Our ref: DOC20/34072

Inland Rail Narrabri to North Star – Submissions Preferred Infrastructure Report

Thank you for your email dated 9 December 2019 to the Biodiversity and Conservation Division (BCD) of the Department of Planning, Industry and Environment inviting comments on the Submissions Preferred Infrastructure Report (SPIR) for the Inland Rail Narrabri to North Star (N2NS) project.

Figure 1
Revised Development Footprint

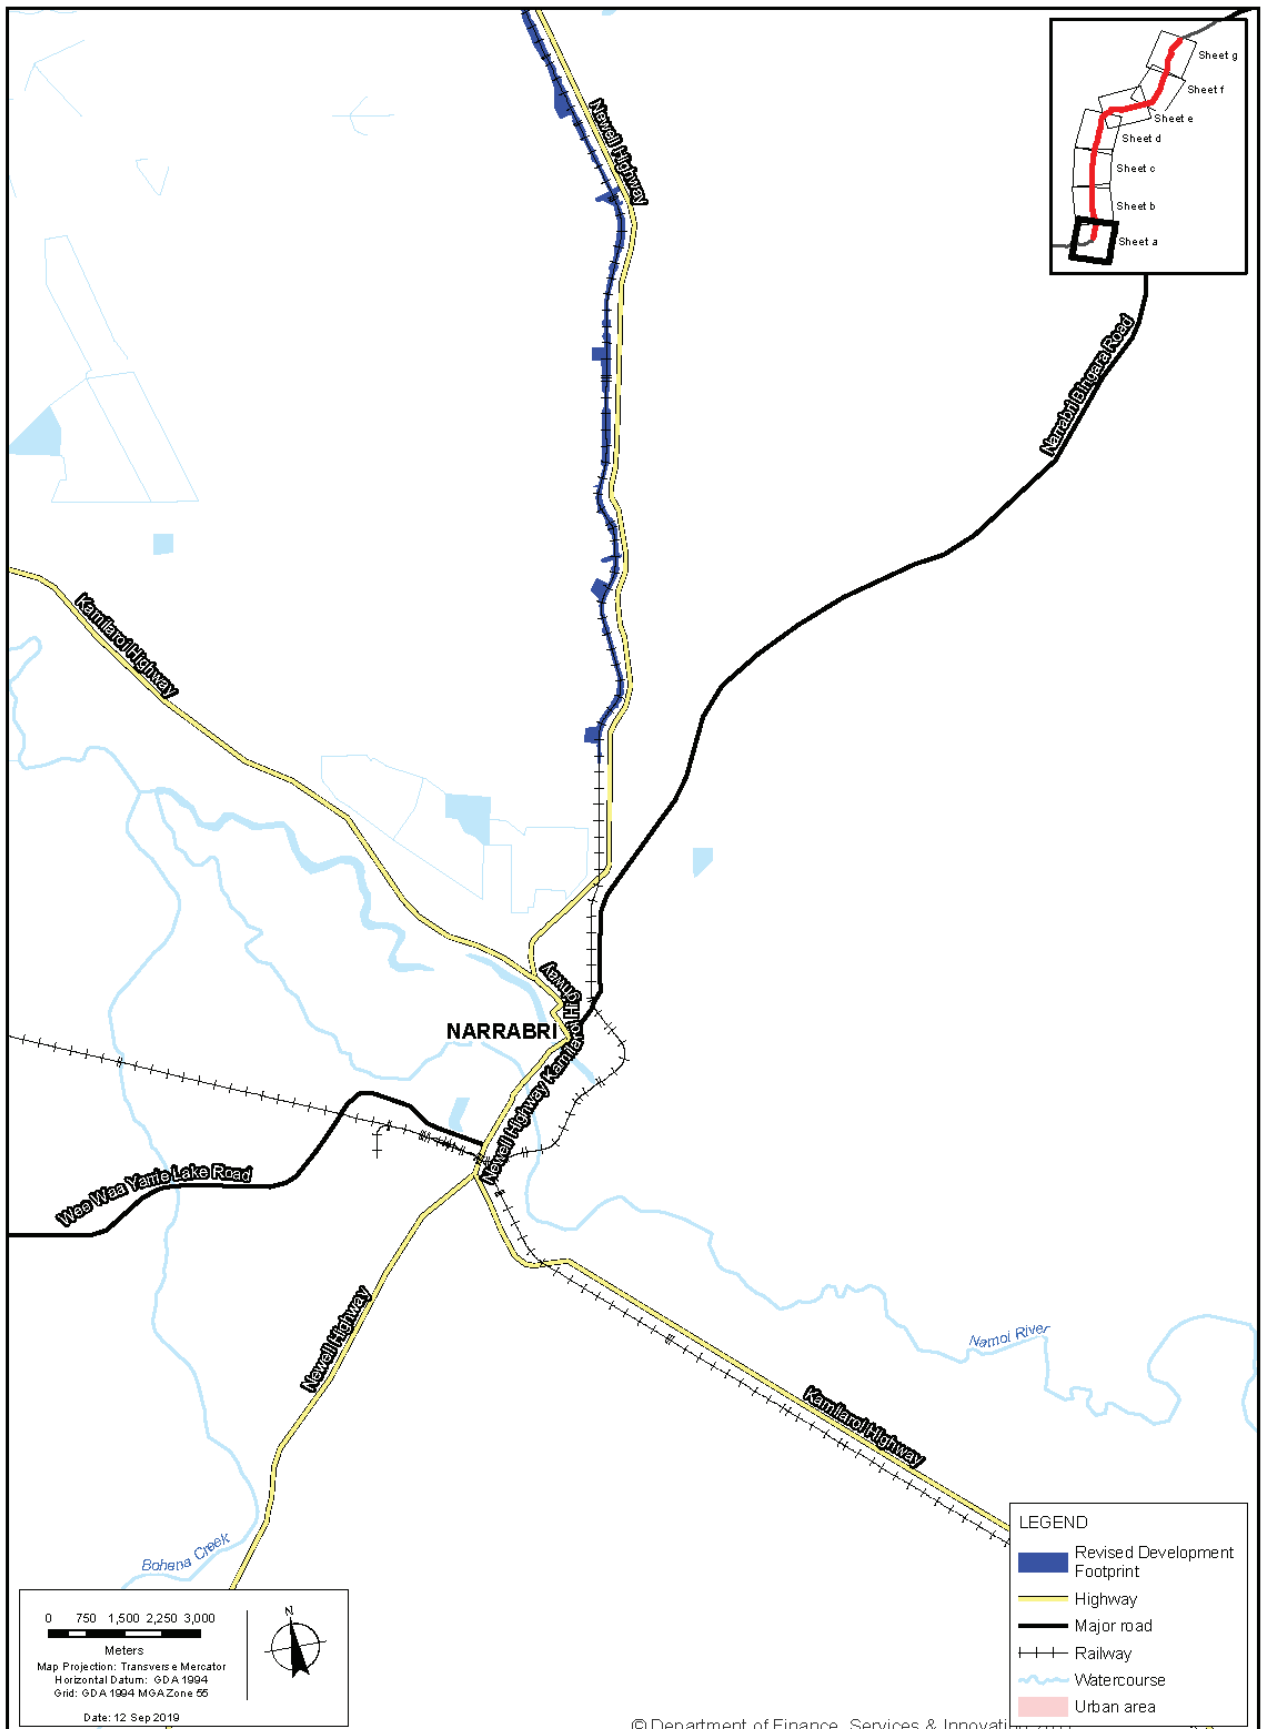
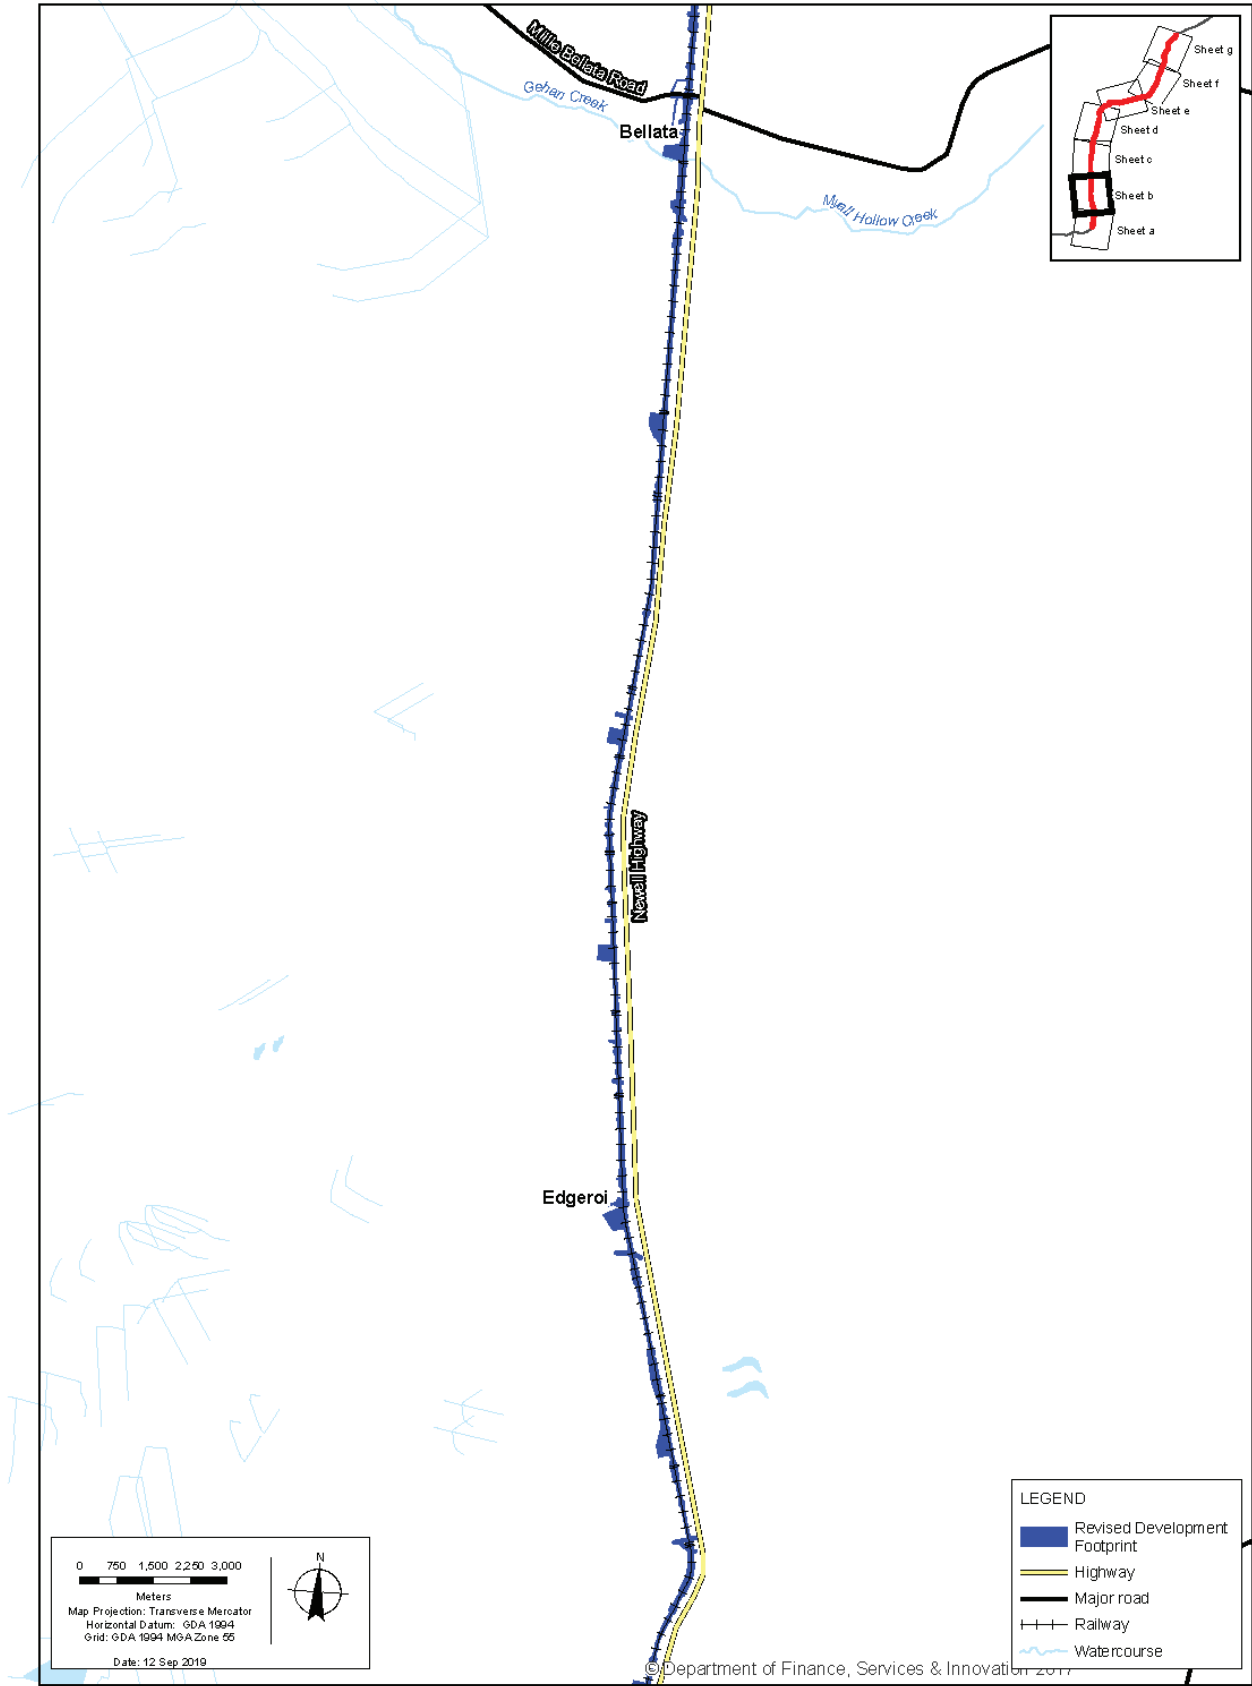
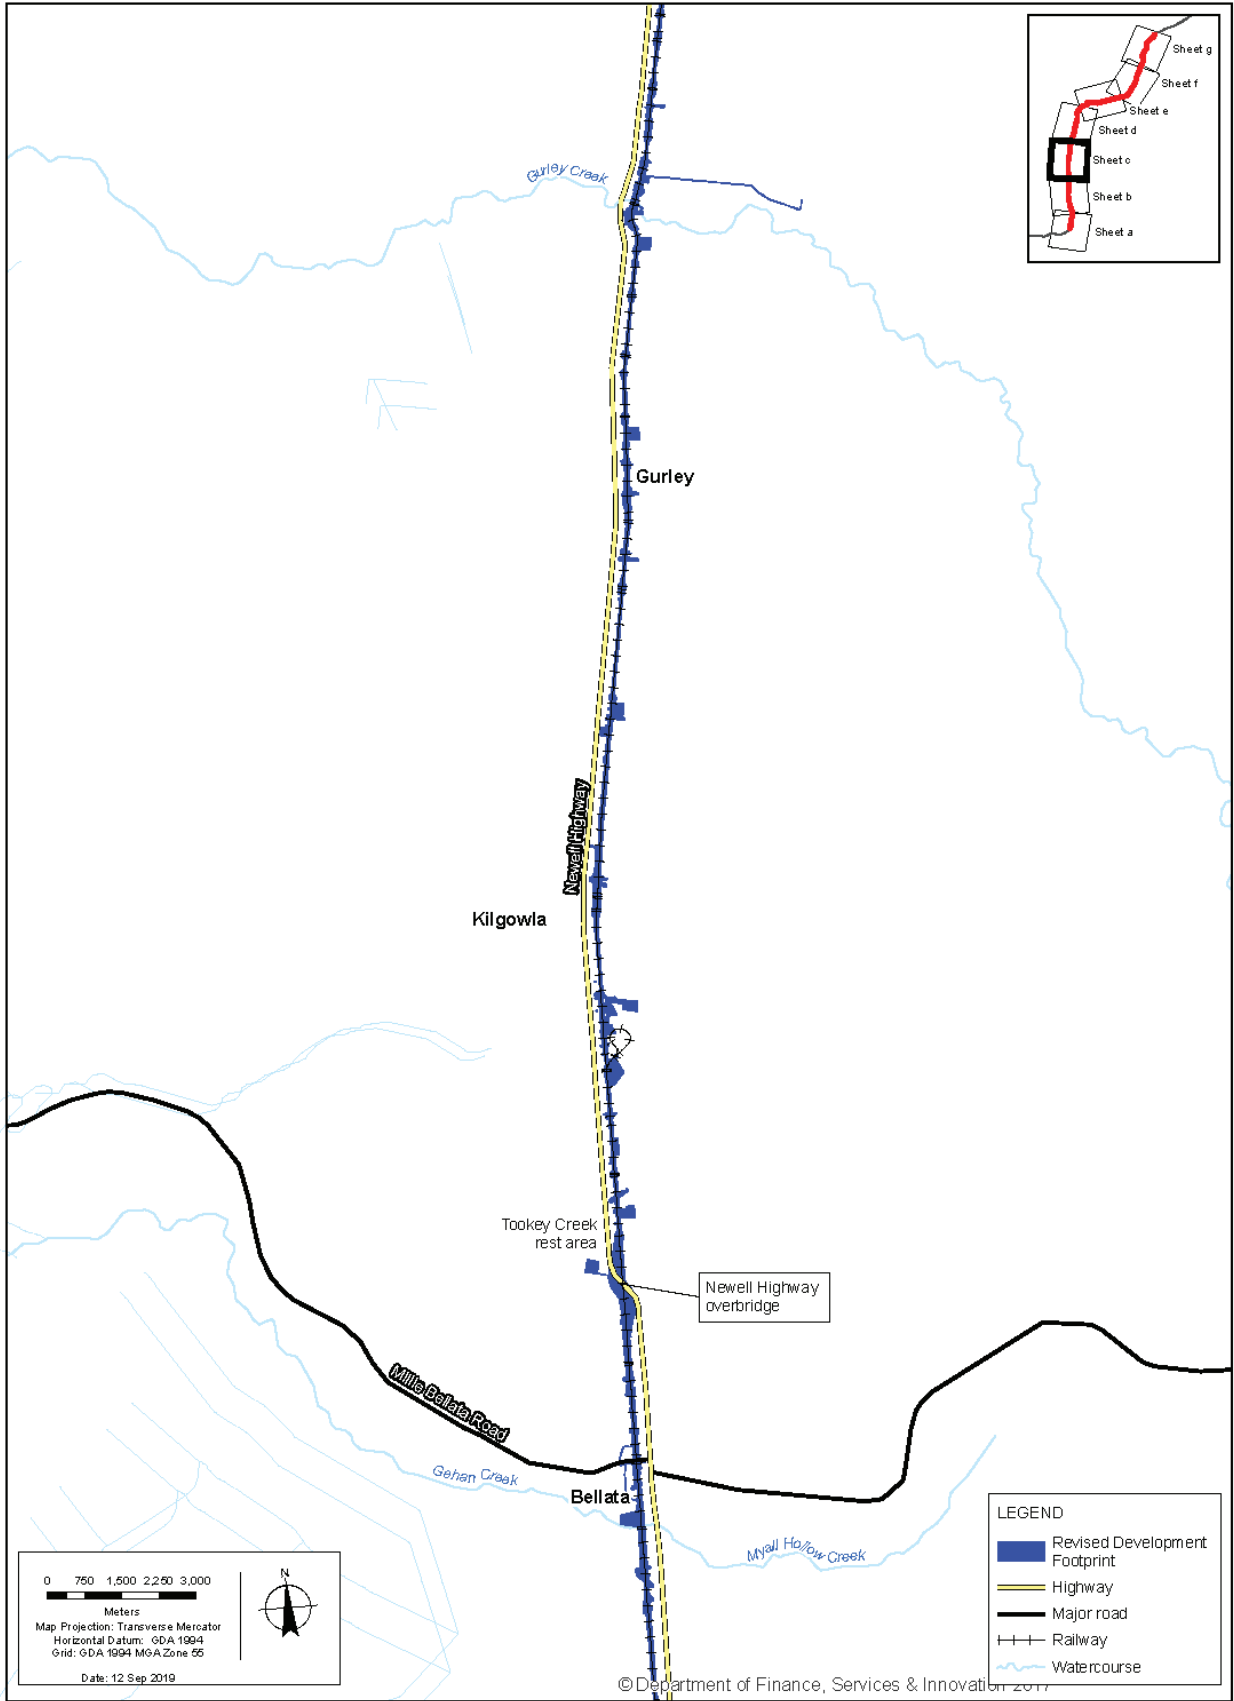
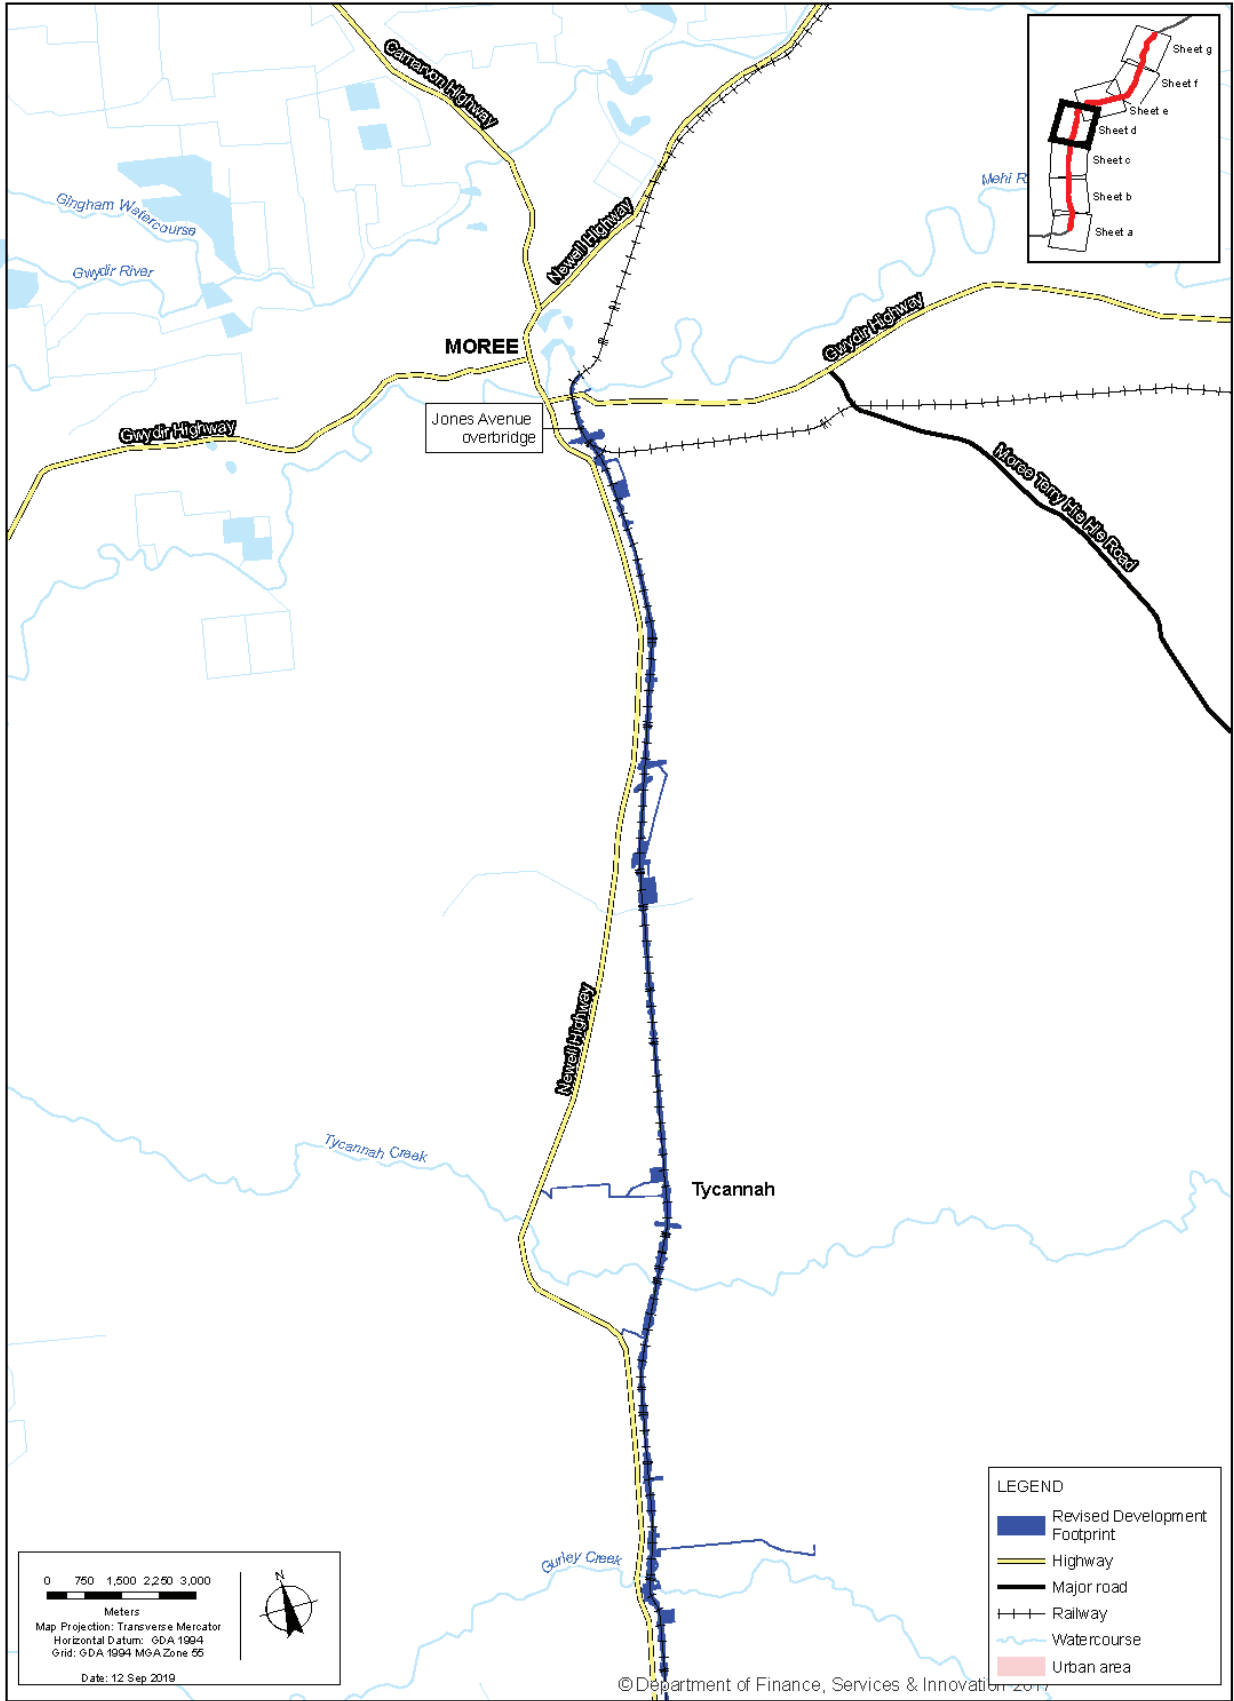
The increased impact to PCTs is detailed in Table 3 and illustrated in Figures 1-7. However, the figures are not displayed at a scale that clearly shows the amended footprint, and they do not illustrate the PCTs being impacted upon. BCD is unable to provide feedback on the validity of the amended impacts to native vegetation without access to this information.

Develop an updated vegetation map, produced at a scale where individual PCTs are easily identified.

Provide BCD with updated spatial files, including the amended footprint, updated vegetation map, and location of rapid assessment plots.
